RE: Pamela Road Extension/Subdivision Amendments

Northeast Civil Solutions (NCS) is in receipt of comments from Woodard and Curran.

Comments Provided by David Senus, P.E.

TYPICAL TRENCH SECTION DETAIL
NOT TO SCALE

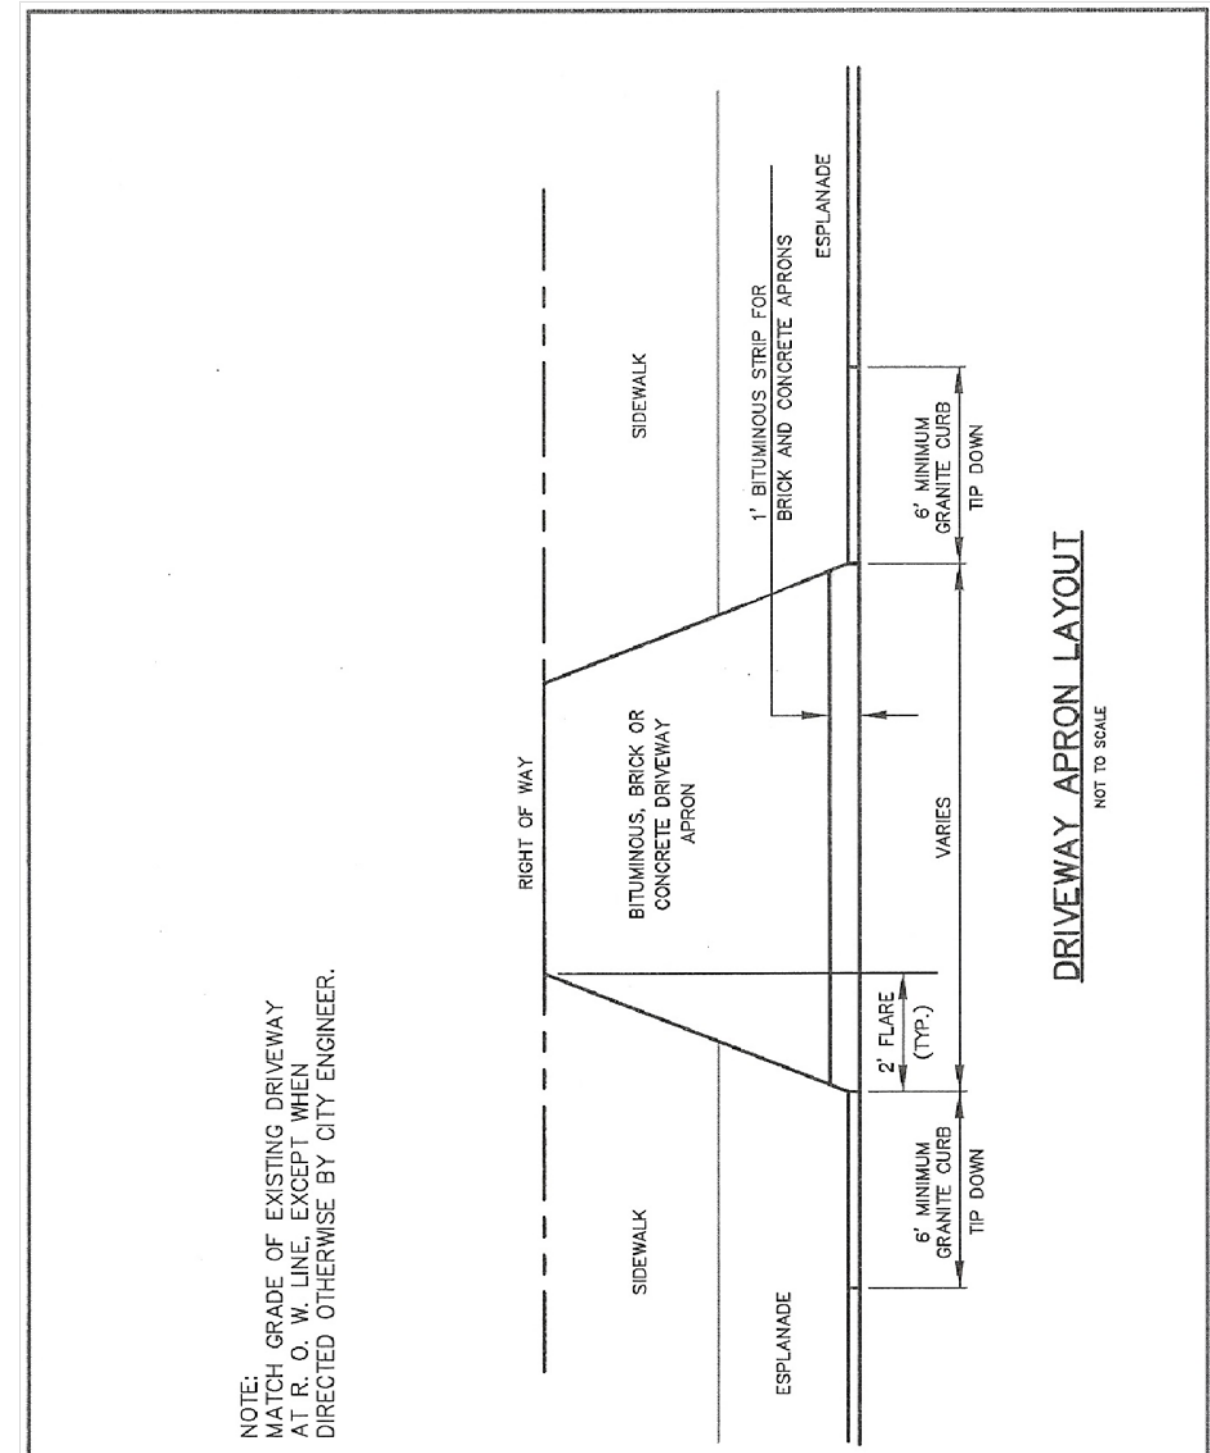
5) The "Sewer Trench Section" detail on Sheet 9 is not a City Standard detail and should be deleted. The sewer pipe installation should follow the Typical Stormwater Trench Section Detail on Sheet 8 (and the detail name should be revised to "Typical Trench Section Detail"). **The sewer trench detail has been eliminated and the Typical Stormwater Trench Section Detail has been revised.**

Drawing Name and Location:
AMENDED SUBDIVISION PLAN
 CRESTVIEW ACRES, PORTLAND, MAINE

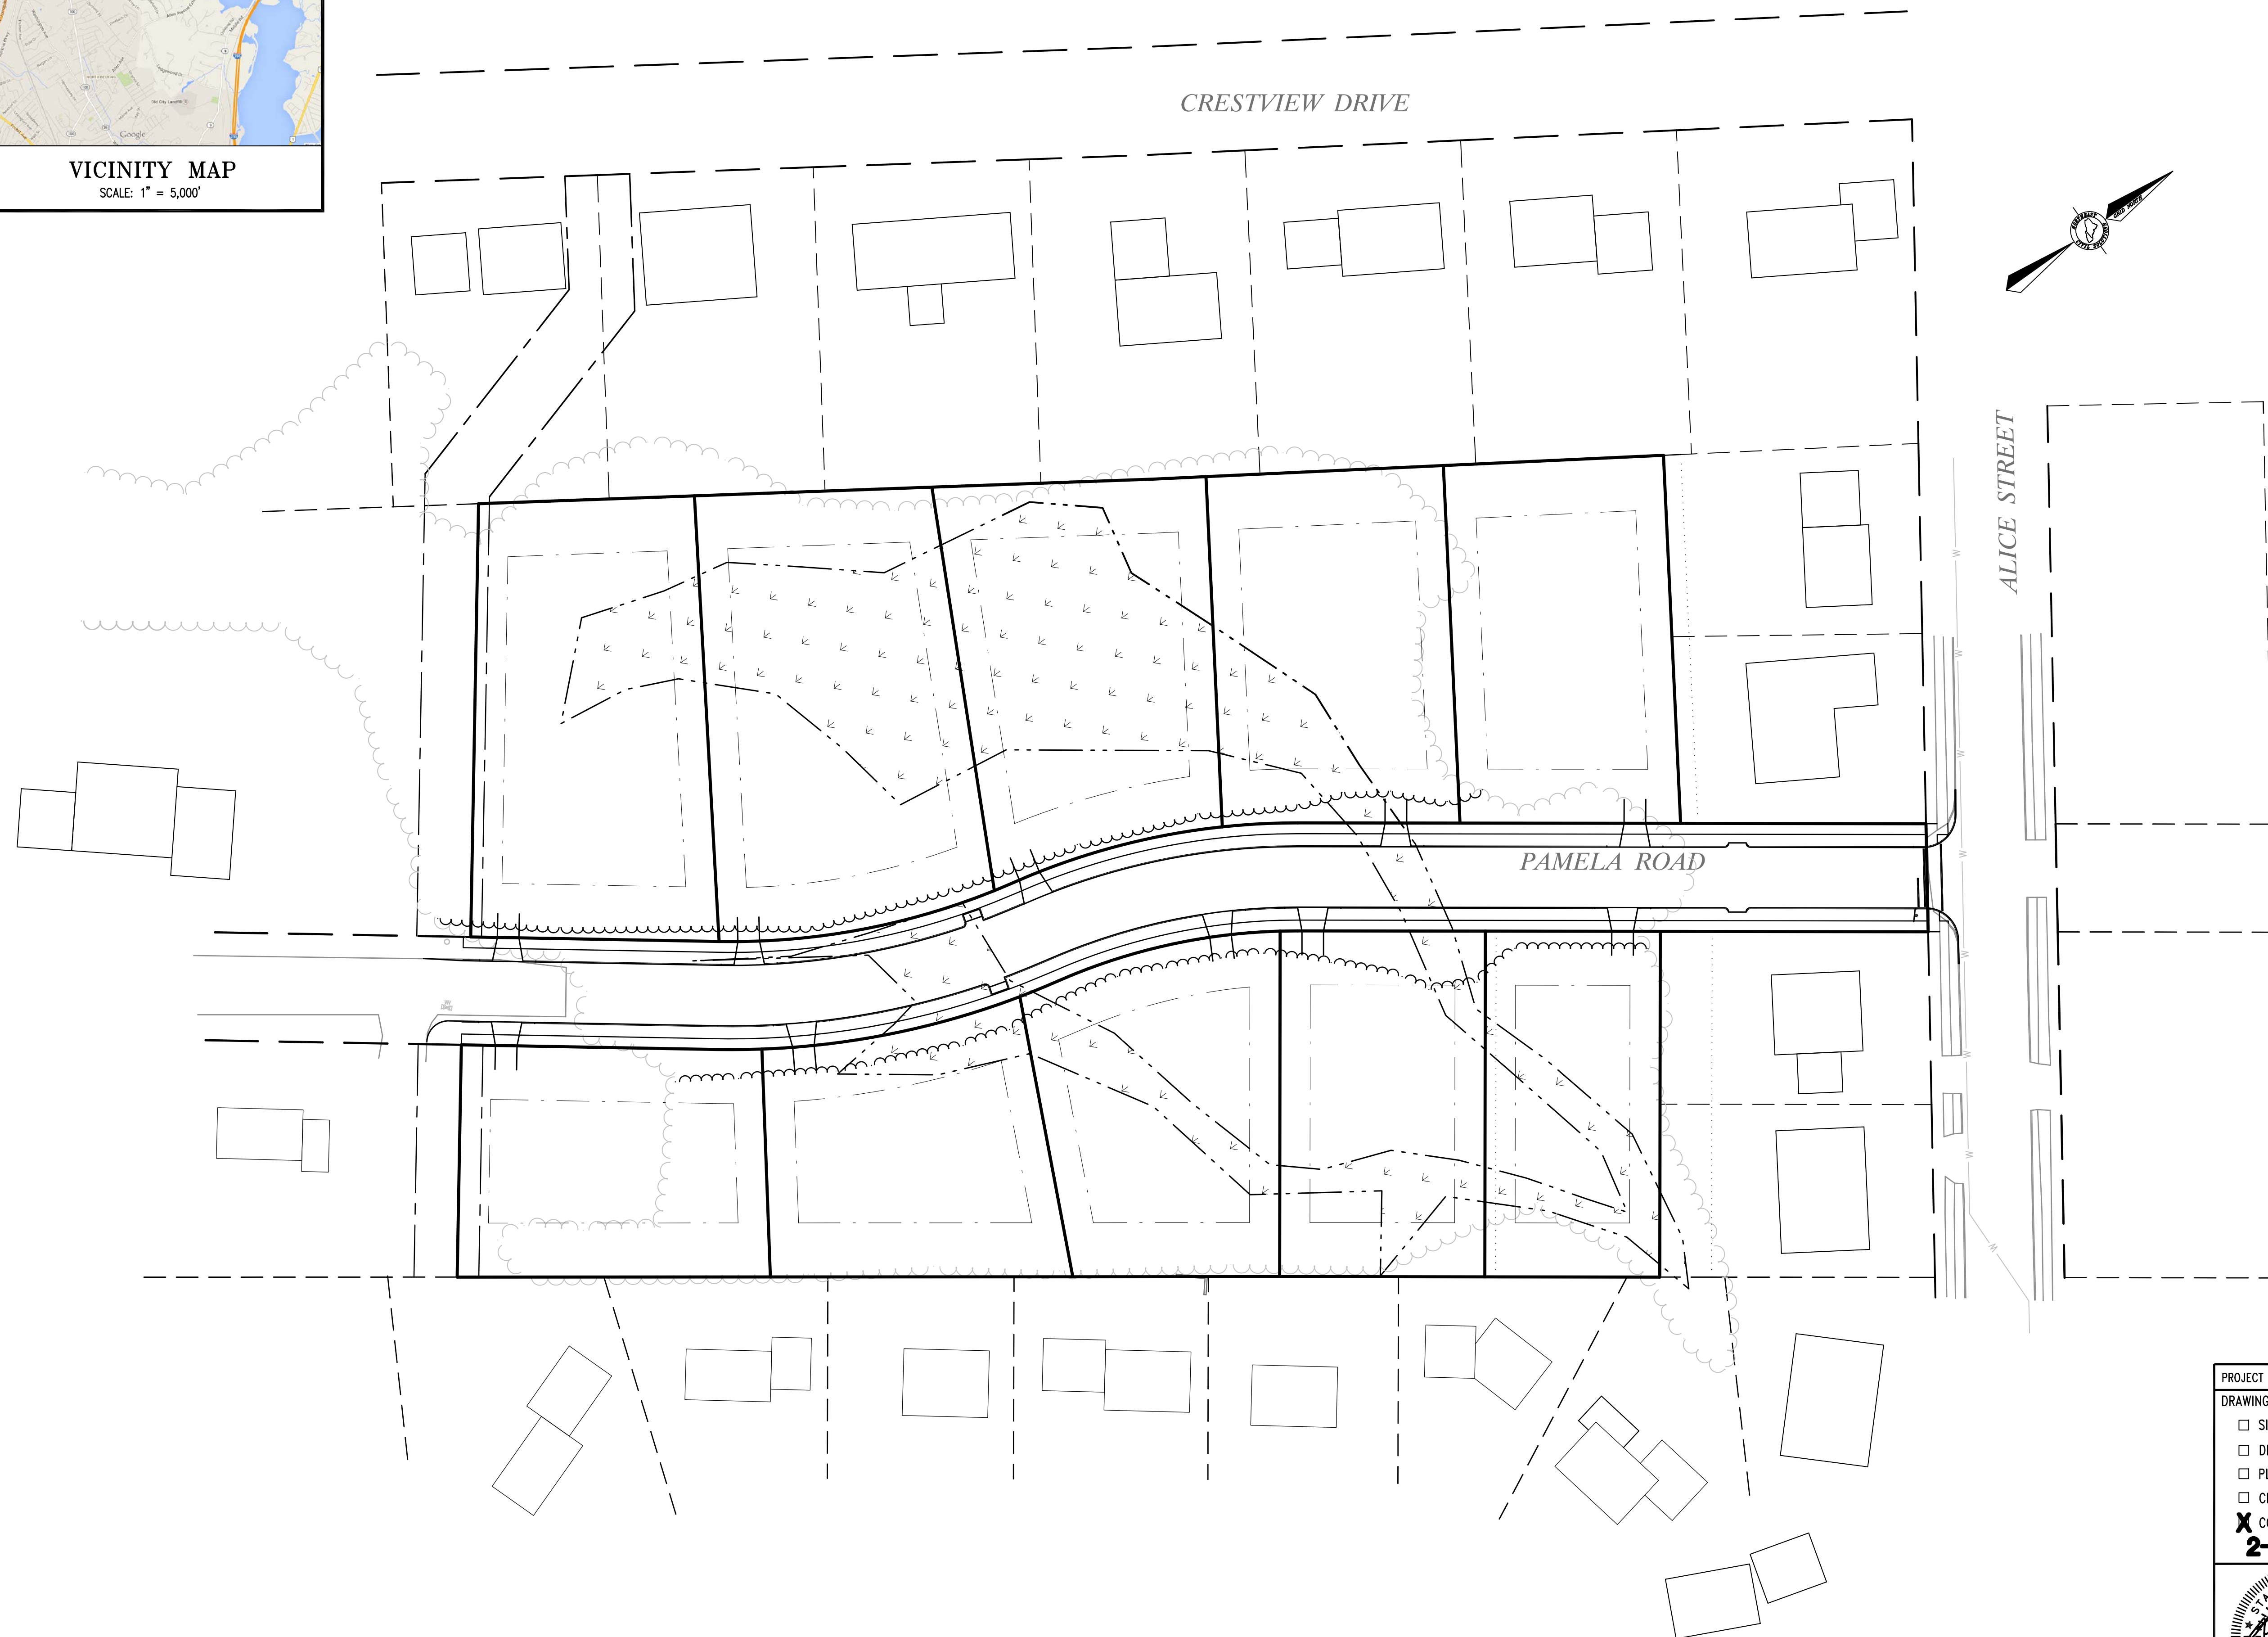
2) The Applicant has received a Natural Resources Protection Act (NRPA) permit (# L-26407-TB-A-N) to fill 5,397 sf of wetland area to construct the proposed roadway. We understand that the Applicant is not prepared to permit potential wetland impacts for the individual house lots. The existing permit states "No wetlands will be altered to develop the individual lots". Additional impacts that may occur to develop these lots will need to be permitted by the individual lot owners (when and if the lots are sold and developed), and we anticipate that the MaineDEP will consider these impacts to be cumulative to the existing permitted impacts for the roadway. As such, we request that the Applicant include a note on the Amended Subdivision Plan (Sheet 2 of 12) that identifies the existing permit number and date, the total permitted area of impact, and that states that additional wetland impacts associated with the development of individual lots along Pamela Road shall be reviewed and approved by the applicable regulatory agencies and may be considered cumulative to all previously permitted impacts. We also recommend including a reference to the existing NRPA permit on the deed for each lot, with similar language to ensure proper disclosure during future property sales. **The suggested language has been added to the Amended Subdivision Plan.**

PAMELA ROAD EXTENSION PROFILE

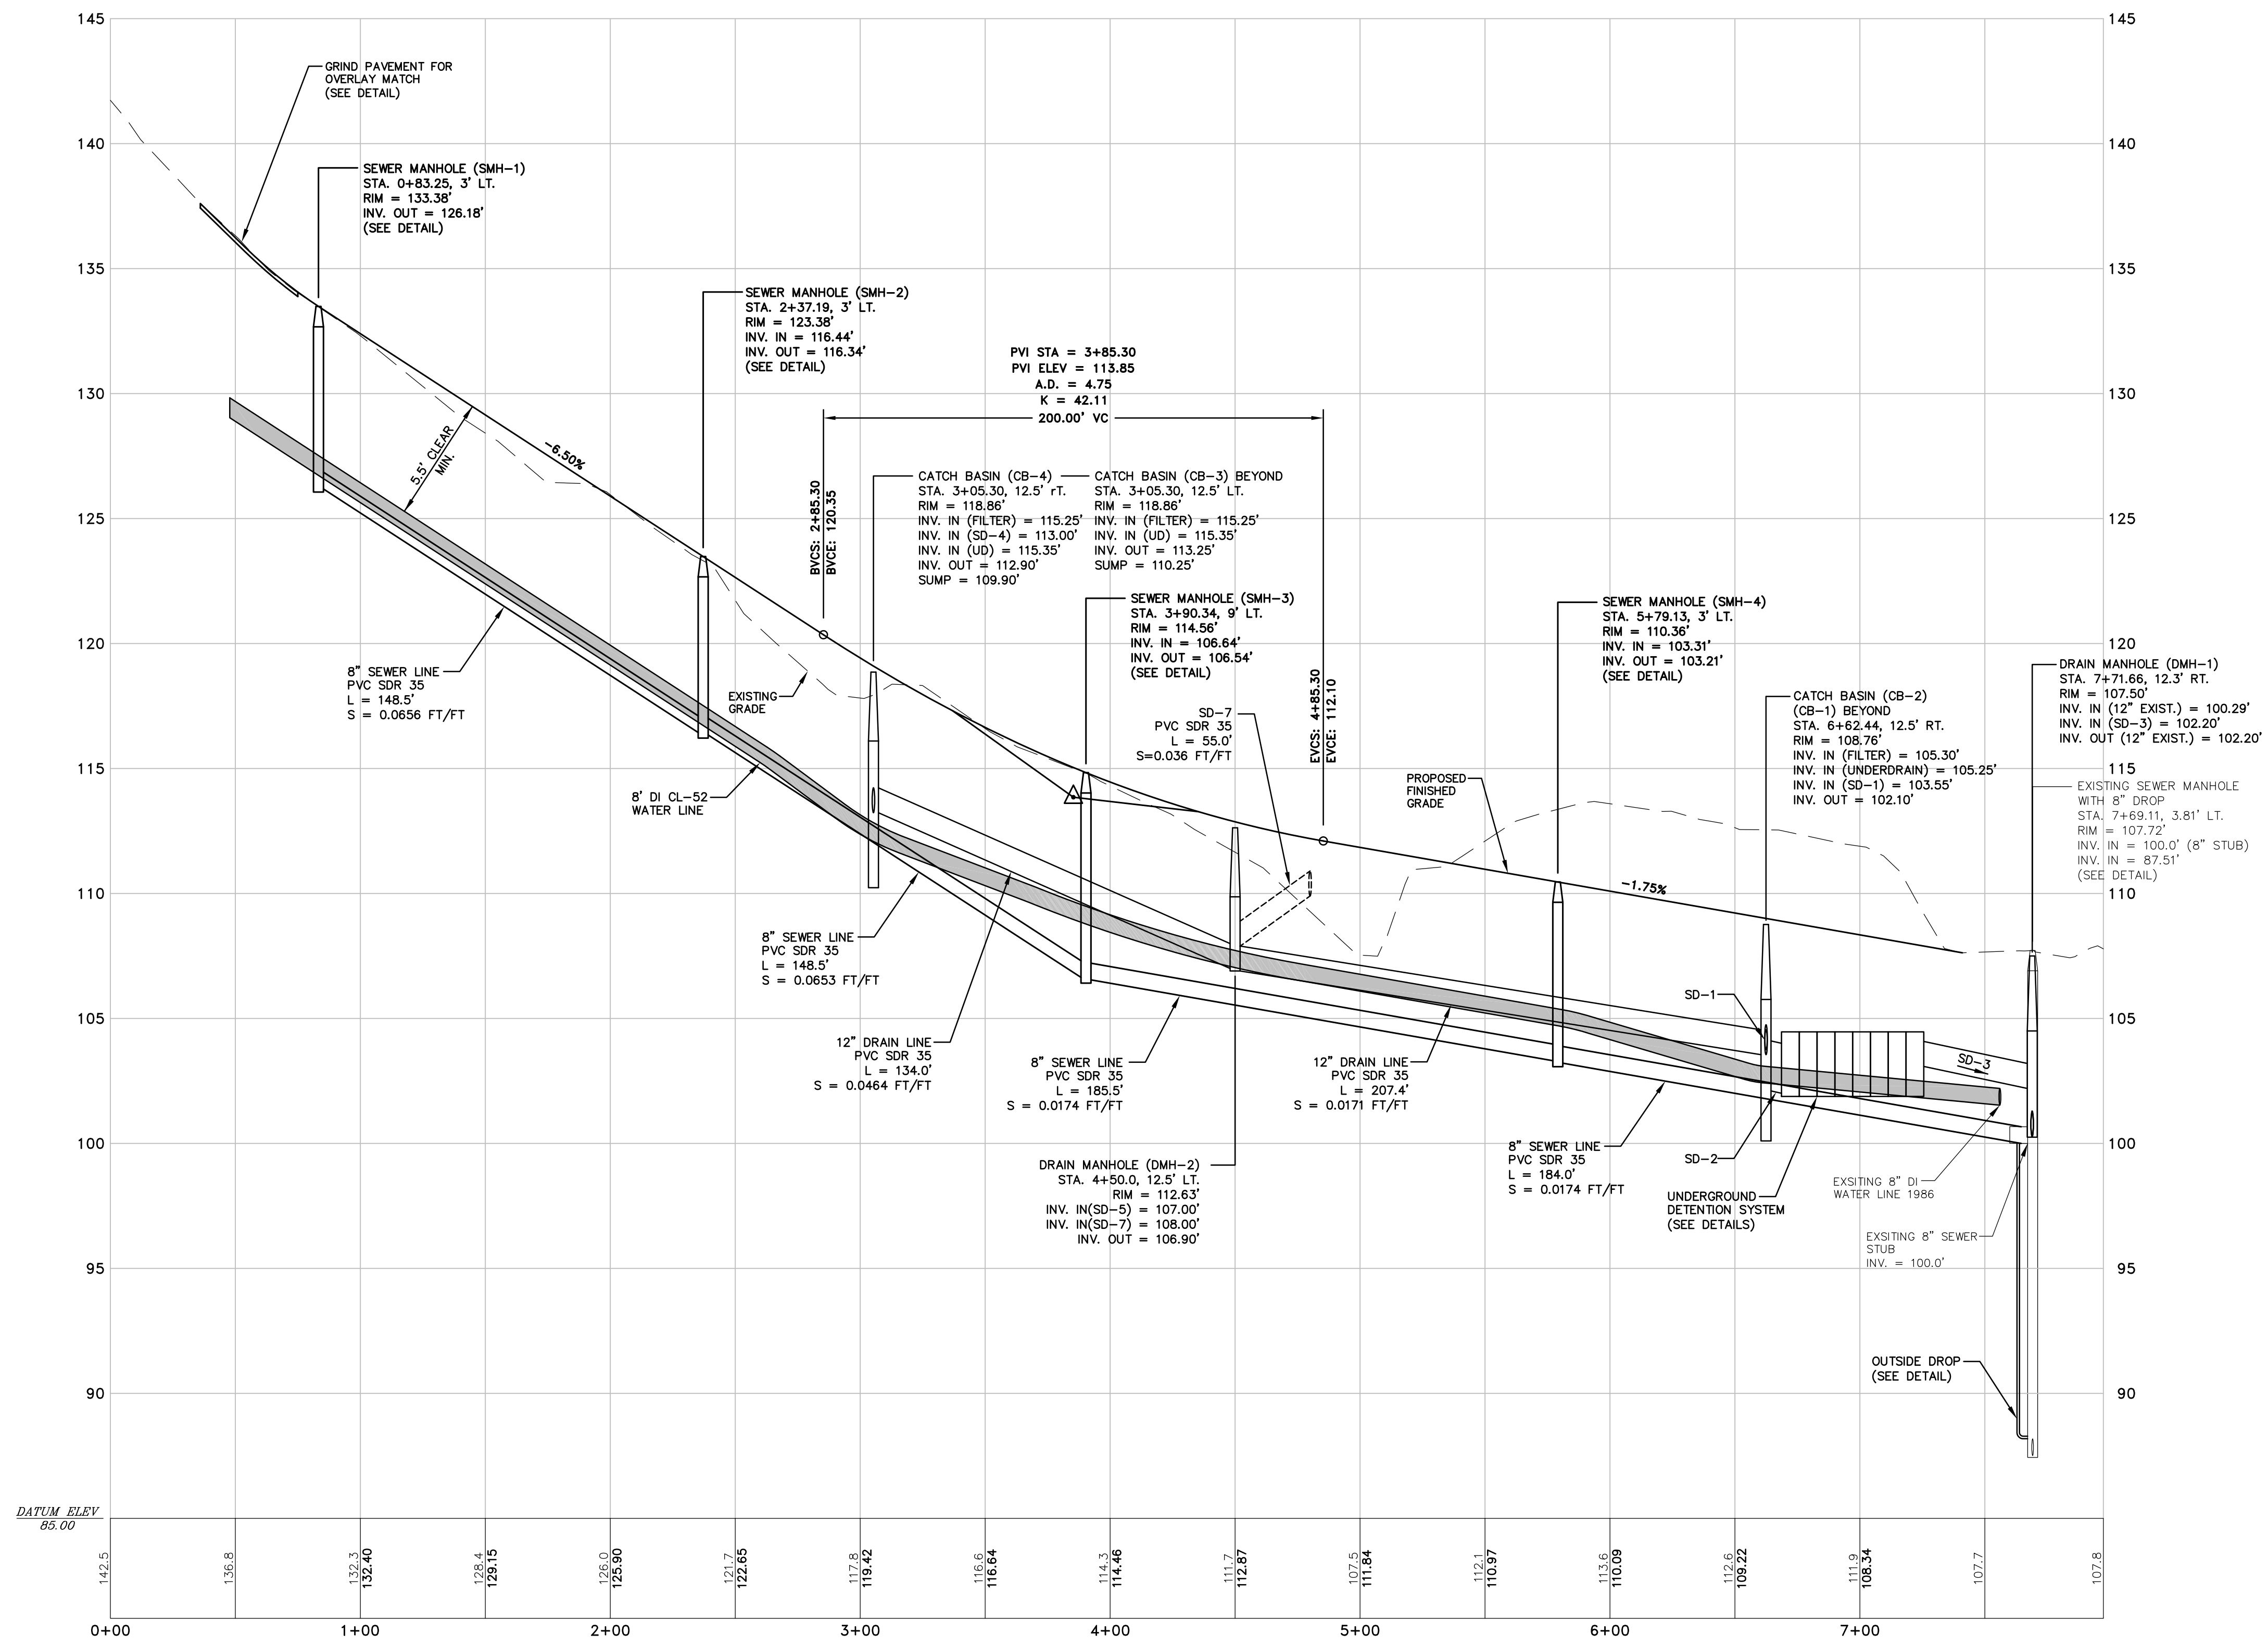
4) A cross culvert is necessary at STA 5+00 to allow drainage from the west side of the proposed roadway to drain to the east. The current design would create an impoundment of the wetland on the west side of the road with no outlet. The contributing drainage area west of the proposed roadway should be evaluated to size this cross culvert. We apologize for not identifying this on our initial review. **A culvert has been added to the plan at station 4+80. Drainage from the west side of the road will be connected to drain manhole number two. See plan and profile for more details.**
